55 MANOR WAYE - 79776/APP/2025/2820

VALIDATION OFFICER CALCULATIONS:

PROJECT:	DORMER EXTENSION	DETAIL:	EXISTING AND PROPOSED FRONT AND REAR
CLIENT:	Mr S Singh	DRAWING NO:	2025-Manor-L-03
SITE:	55 Manor Waye Hillingdon Middx UB8 2BE	DATE:	30th Aug 2025
SCALE:	1 : 100	REV:	DRAFT
		DRAWN BY:	A3

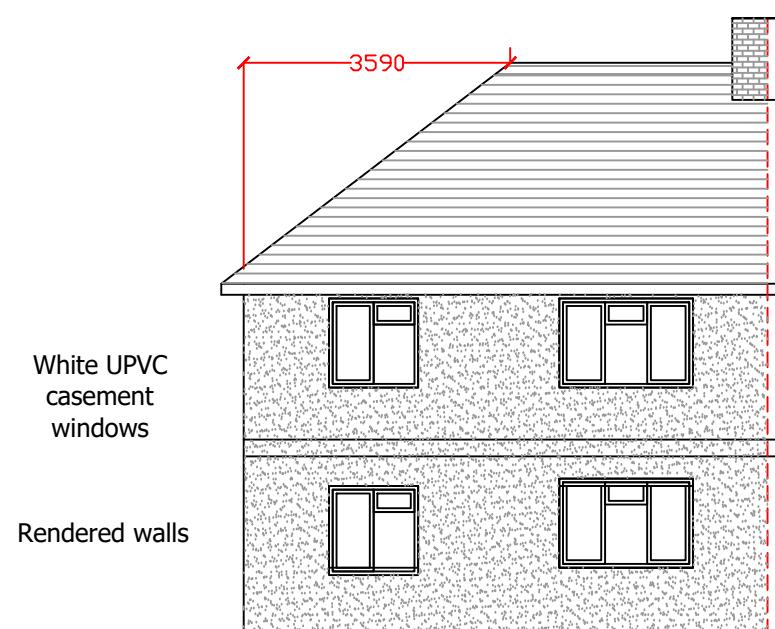
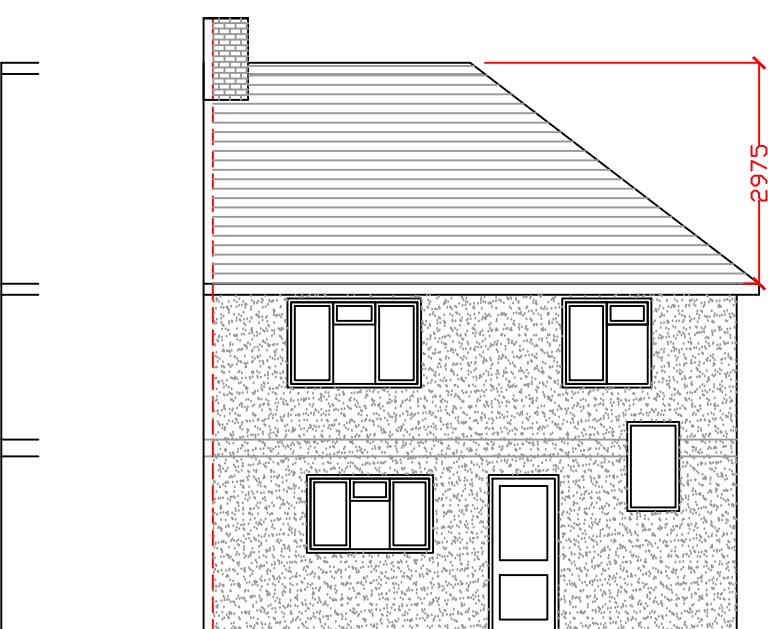
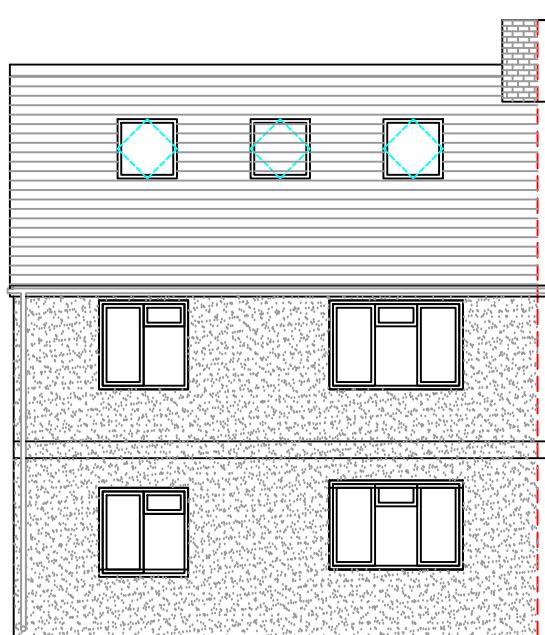
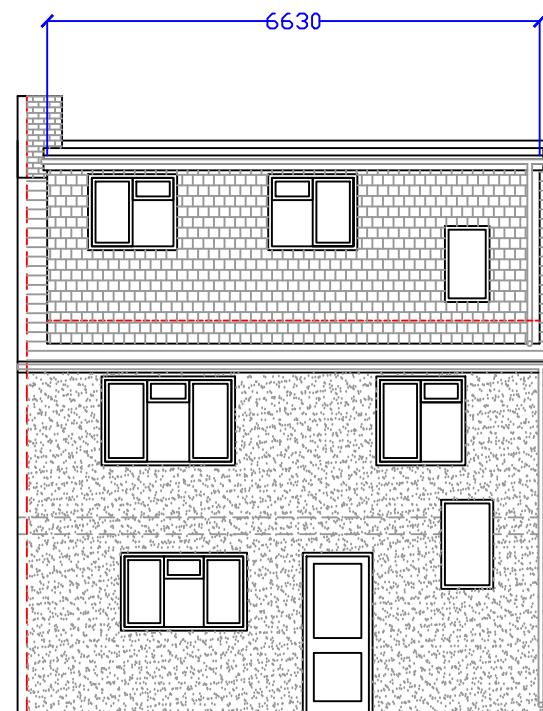
Vol of rear dormer:

$$(6.63 \times 3.33 \times 2.59) / 2$$

$$= 28.59 \text{ m}^3$$

Vol of Hip to Gable end:

$$(7.78 \times 3.73 \times 2.84) / 6$$

$$= 13.74 \text{ m}^3$$

Total Volume of roof extensions

$$28.59 + 13.74$$

$$= 42.33 \text{ m}^3 < 50 \text{ m}^2$$
